Our reference: ECM Ref: 9811393
Contact: Kathryn Saunders
Telephone: (02) 4732 8567

22 December 2021

Request for Advice - EIS - Kemps Creek Data Centre SSD-10101987 at No. 707 – 769 Mamre Road Kemps Creek

Drawing Title  
ELEVATIONS - SYD05-06

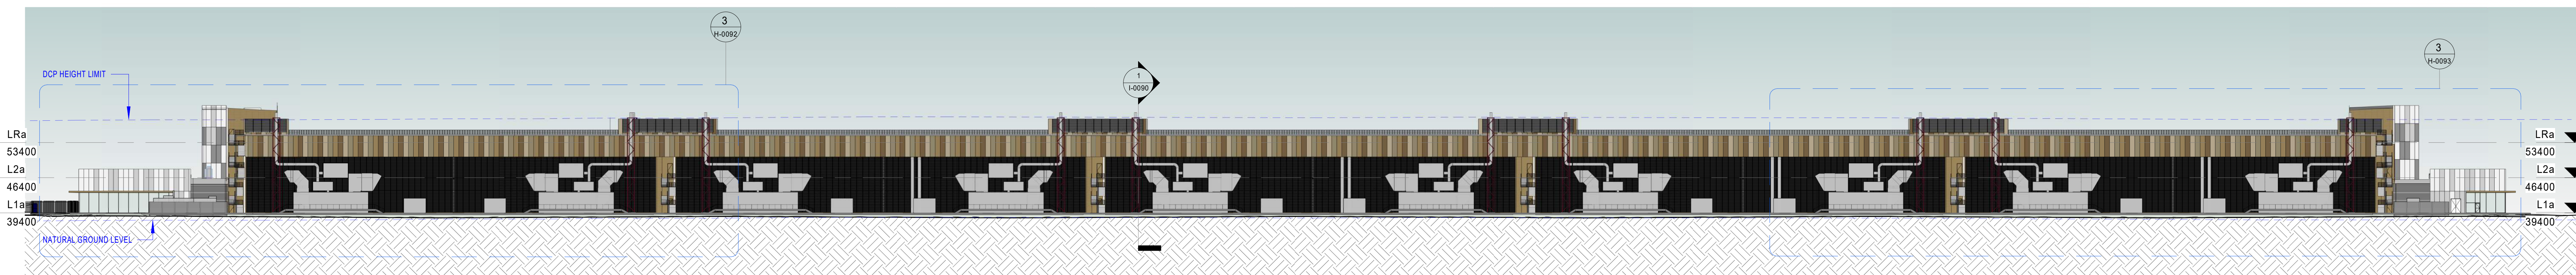
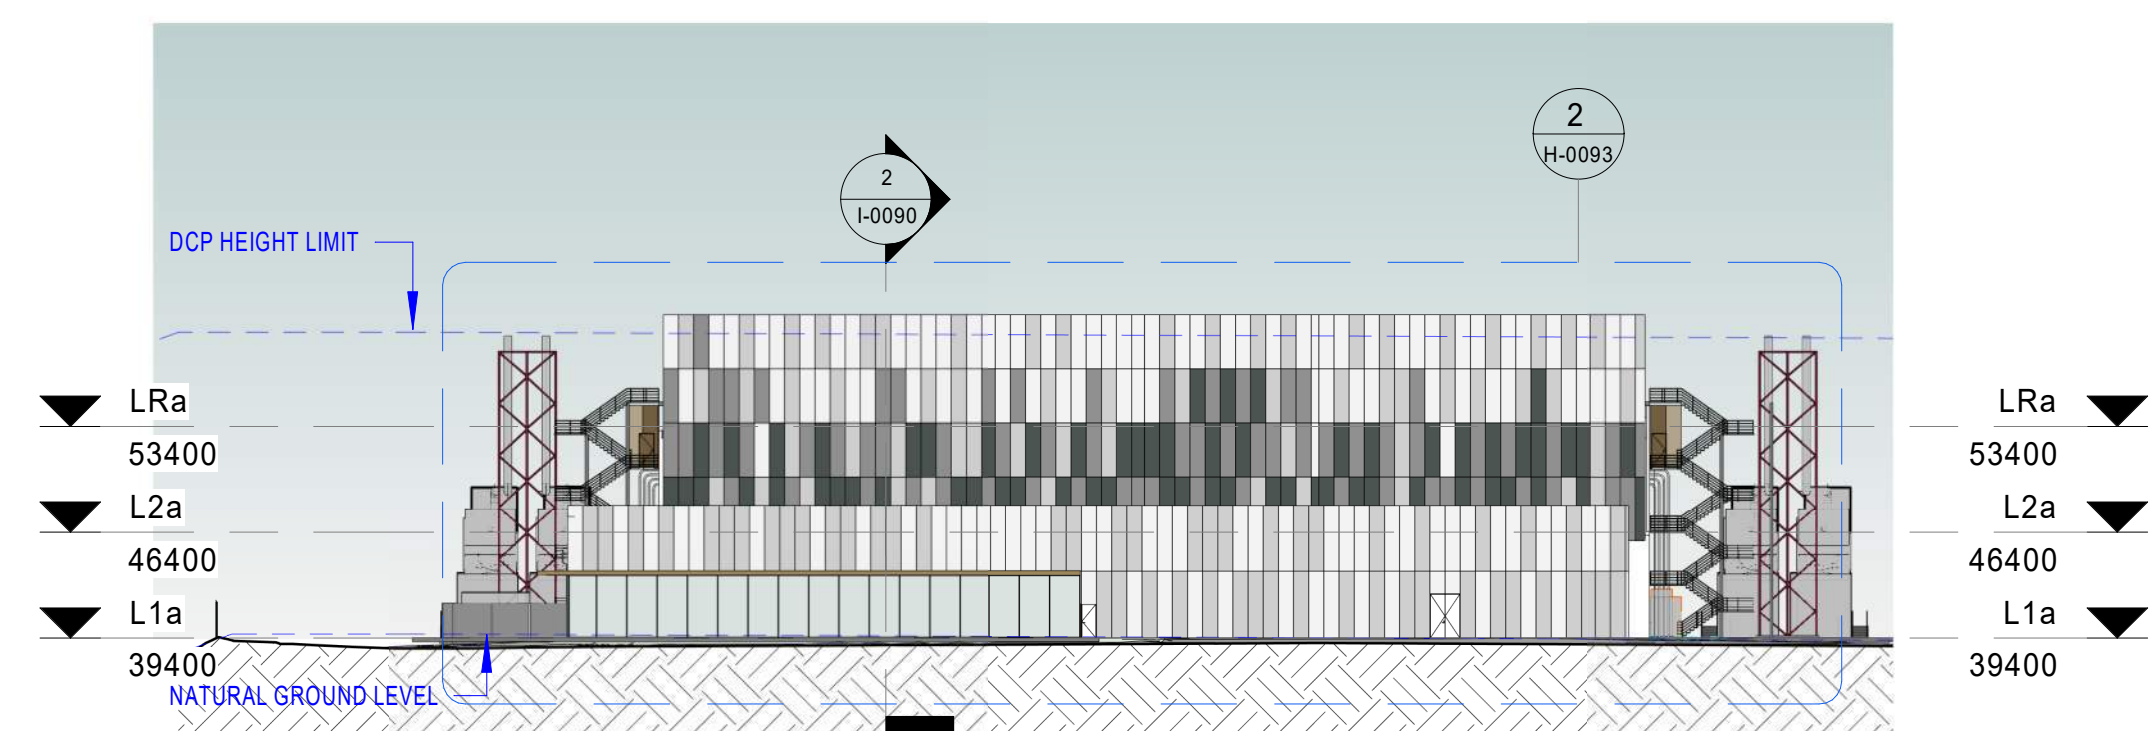
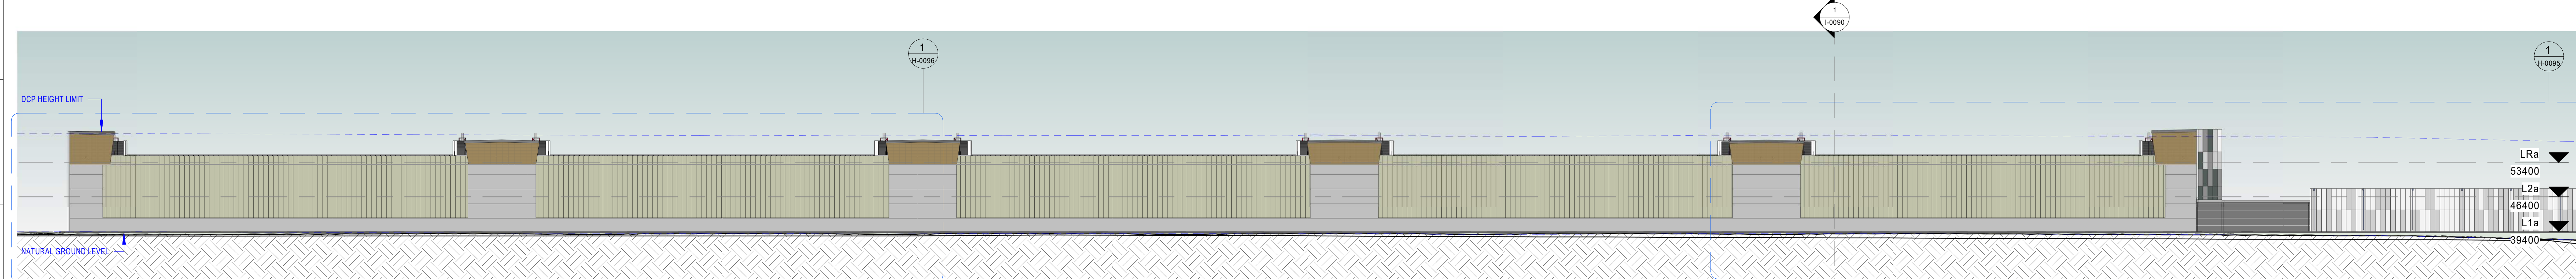
The building arrangement and architectural form provides elongated buildings with minimal varying of materials. The elevations utilise colour as the only form of articulation.

This is not sufficient and is not resolving related issues of bulk and scale.

The multiple small panels with differing colours increase the bulk and scale of the buildings. Colour patterns must be provided over larger areas of each building and are not to be provided in archaic small patches, which is creating busy and confused elevations.

Appreciating the use is a data centre, embellishment into the architectural form should be encouraged to ameliorate the overall mass and repetition of the building as viewed from the streetscape. The materiality mix must be further resolved and elevated.
